**DEVIATION REVIEW
 AND DECISION FORM**

Subdivision or Project Name: Homestead at SR Filing No. 2

Section of ECM from Which Deviation is Sought: ECM 2.3
 Specific Criteria from Which a Deviation is Sought: K Value for "known" stop condition at crest vertical curve.
 Criteria does not exist in the ECM

NIARADA WAY
DEVIATION EXHIBIT FOR "K" VALUE STOP DISTANCE

**NIARADA DRIVE
 STA 0+00.00 TO STA 4+80.89**

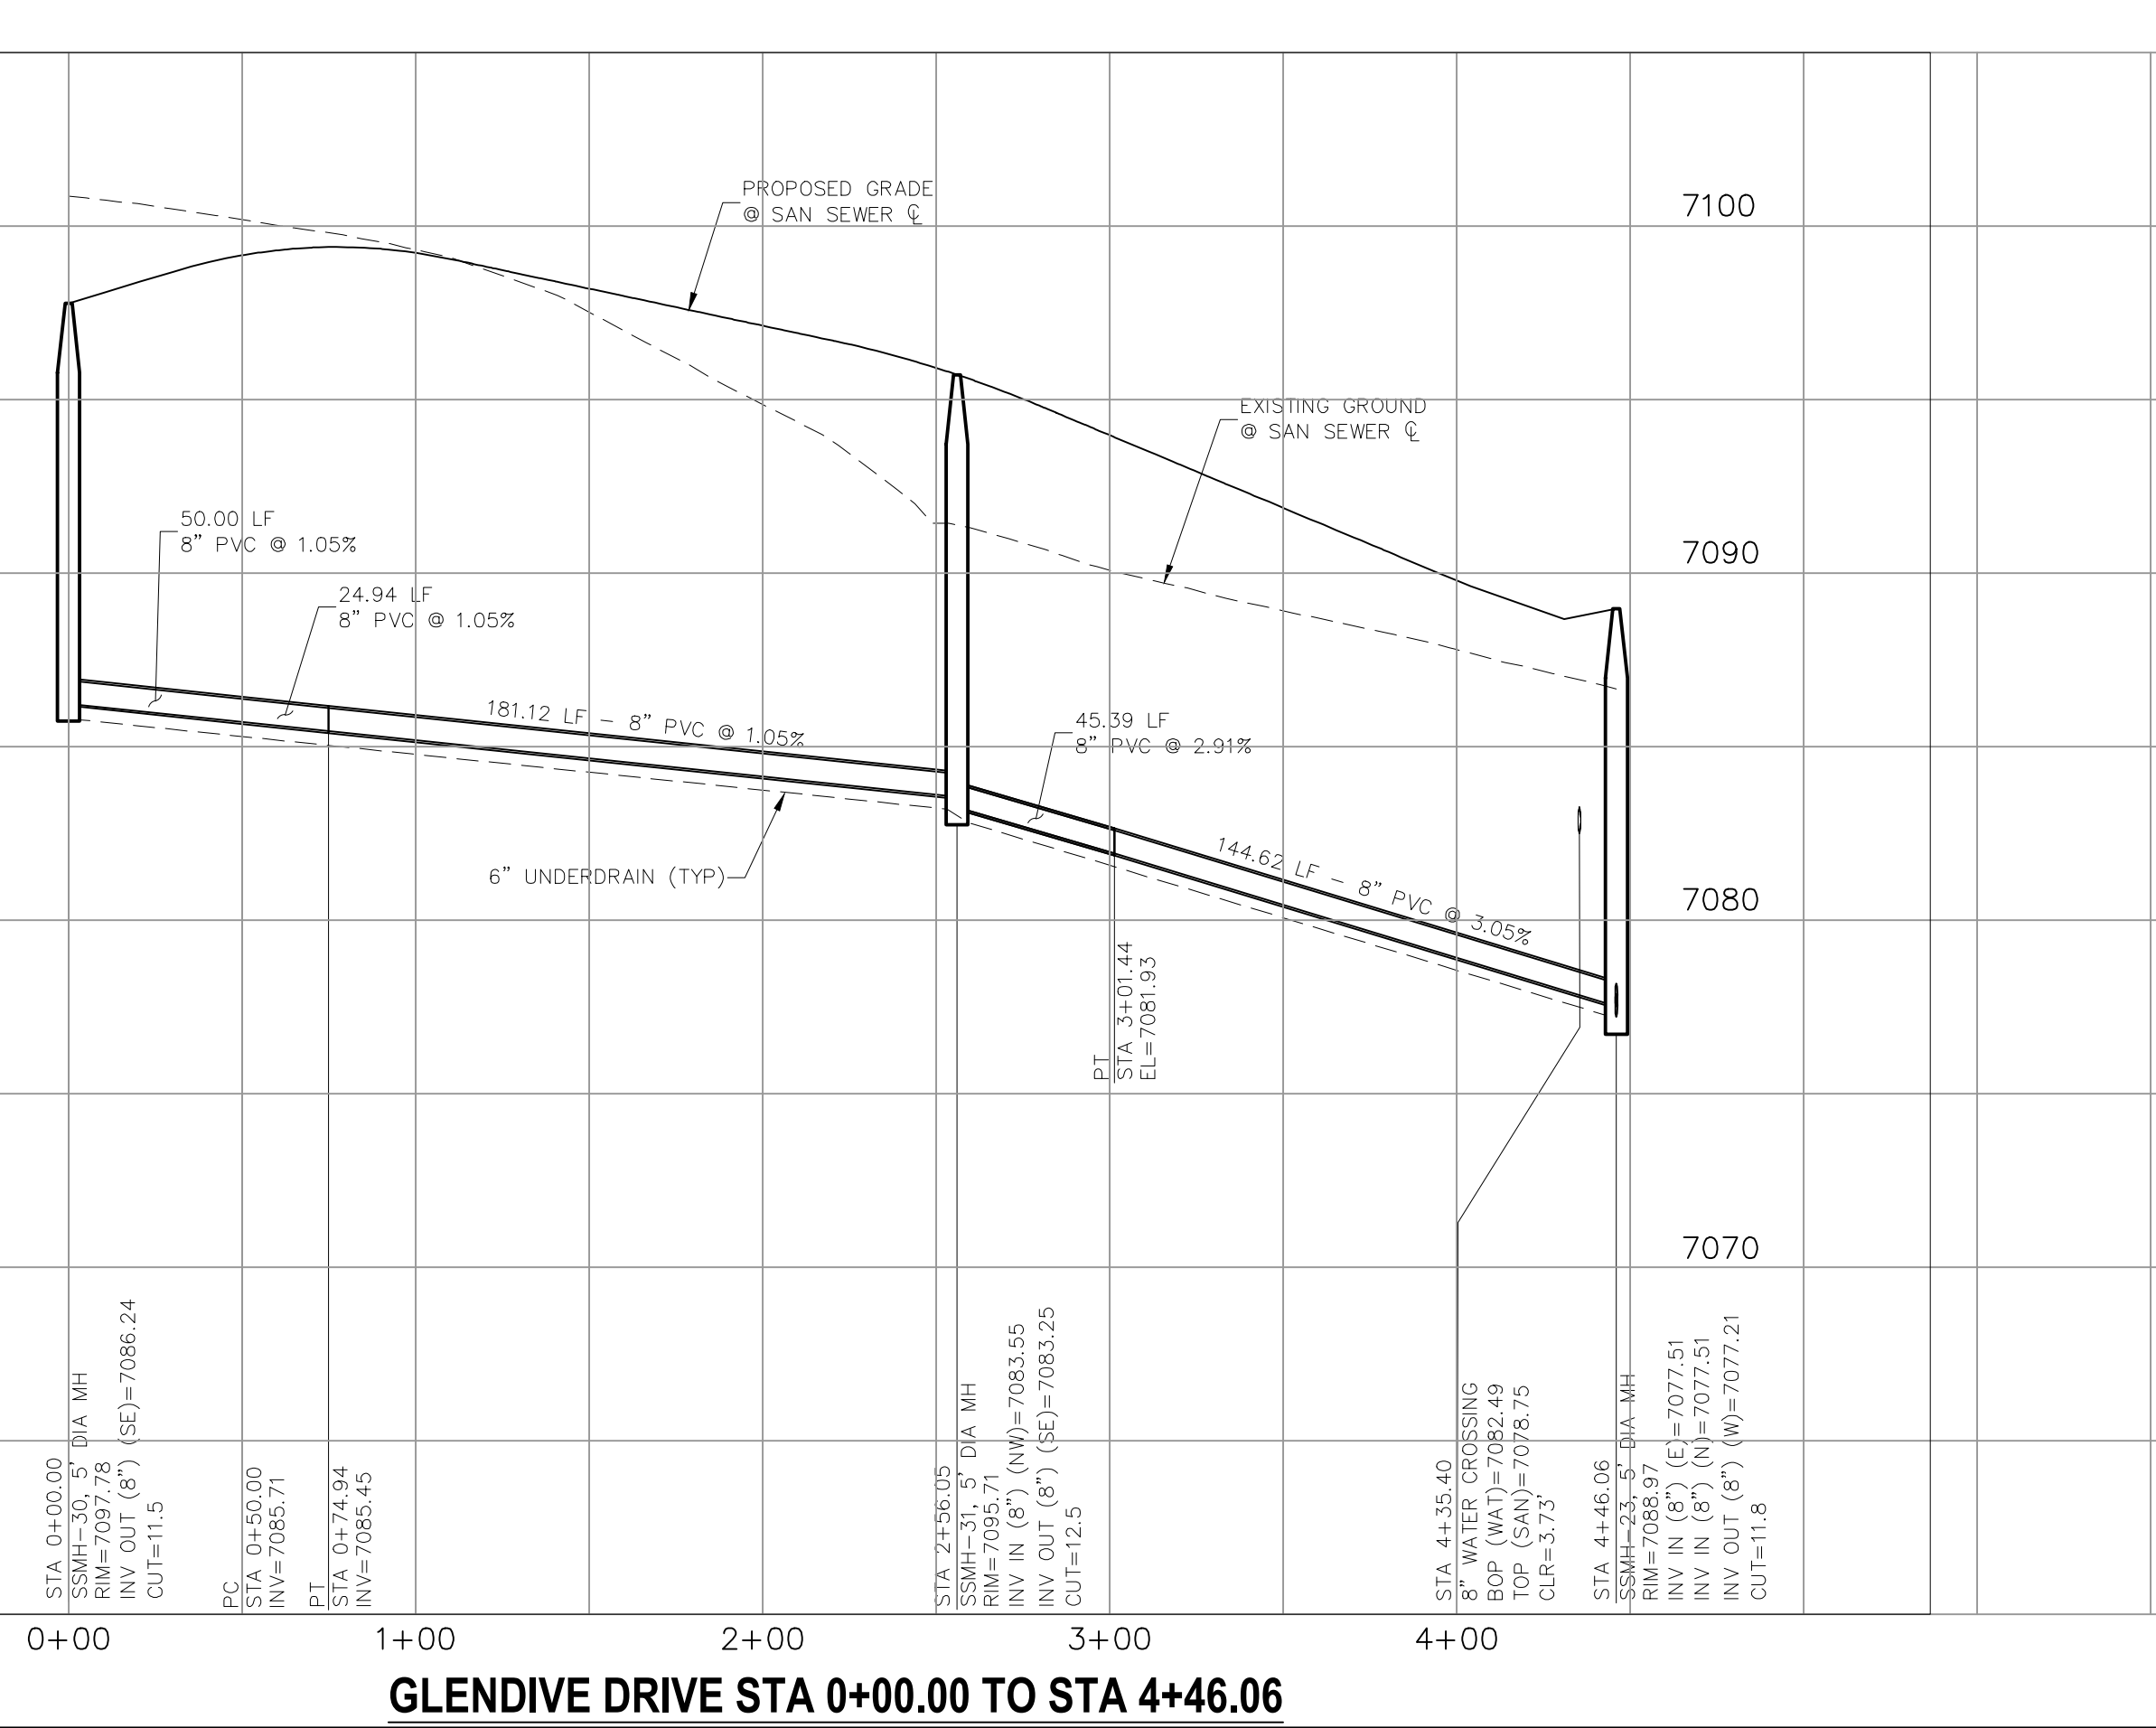
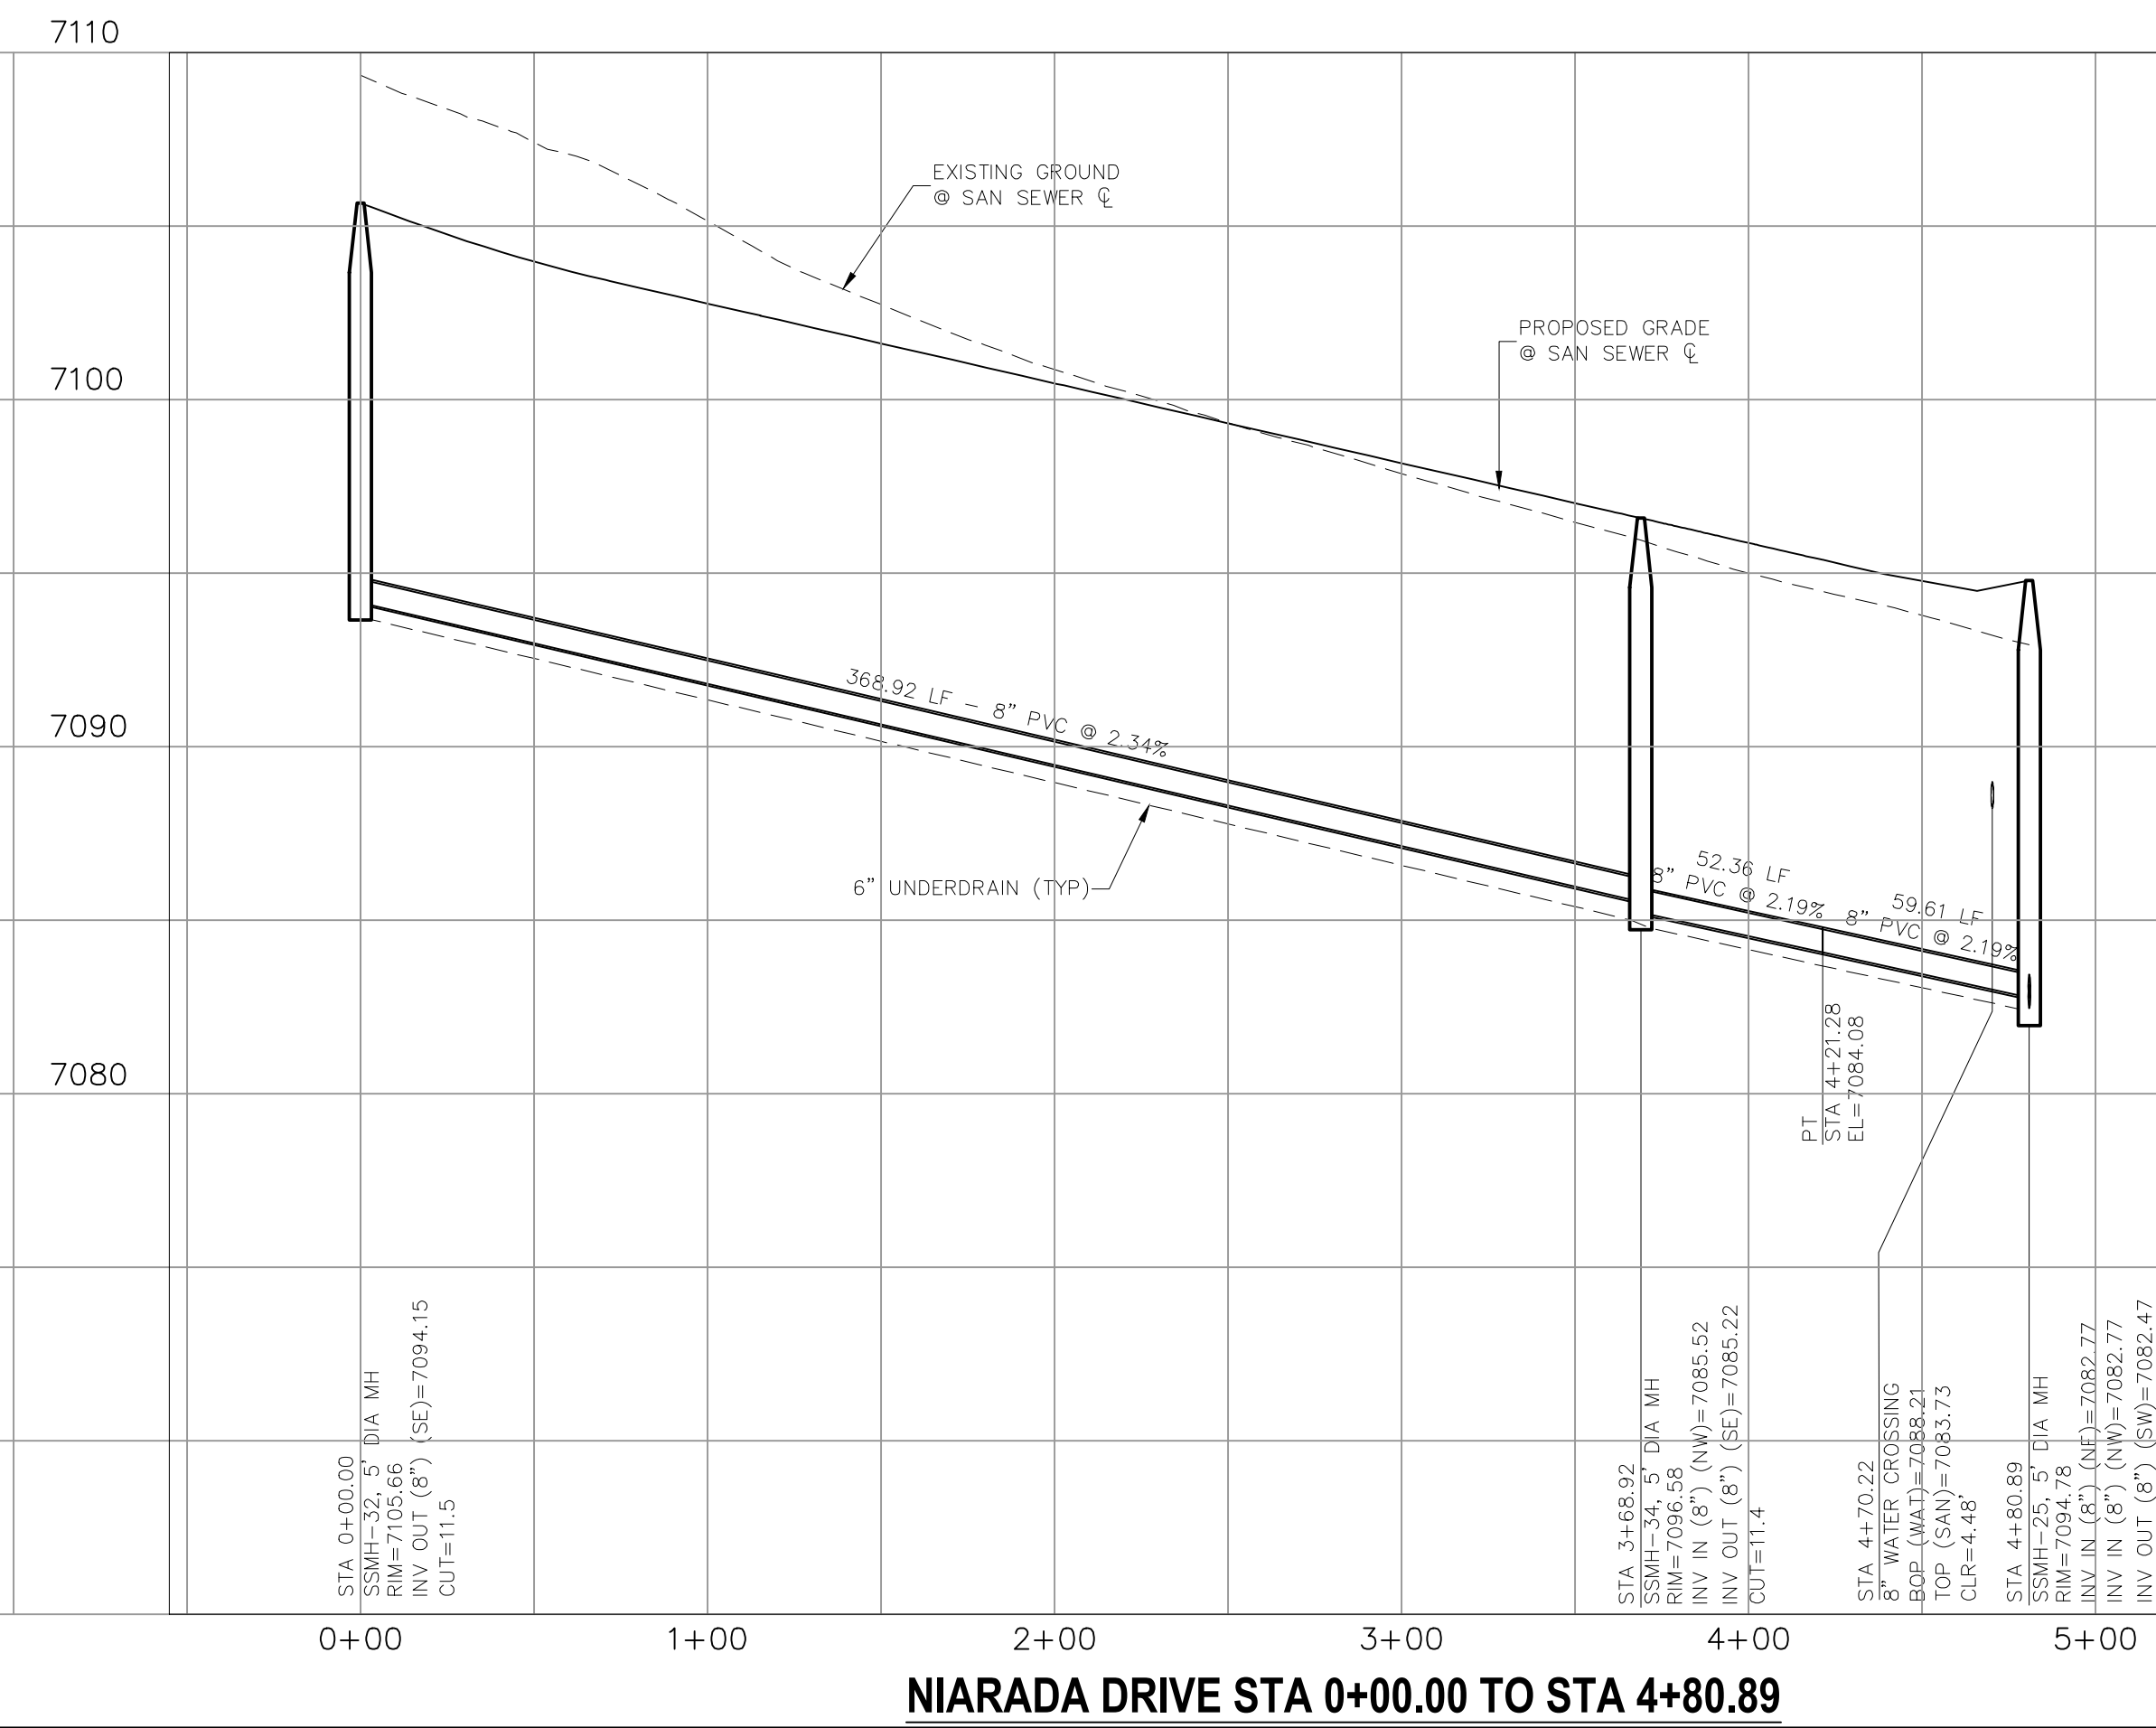
We cannot accept the explanation that the speed is near zero at the crest of the curve. If you are approaching the curve and cannot see the stop sign due to the low "K" value then you would be traveling at or greater than the design speed.
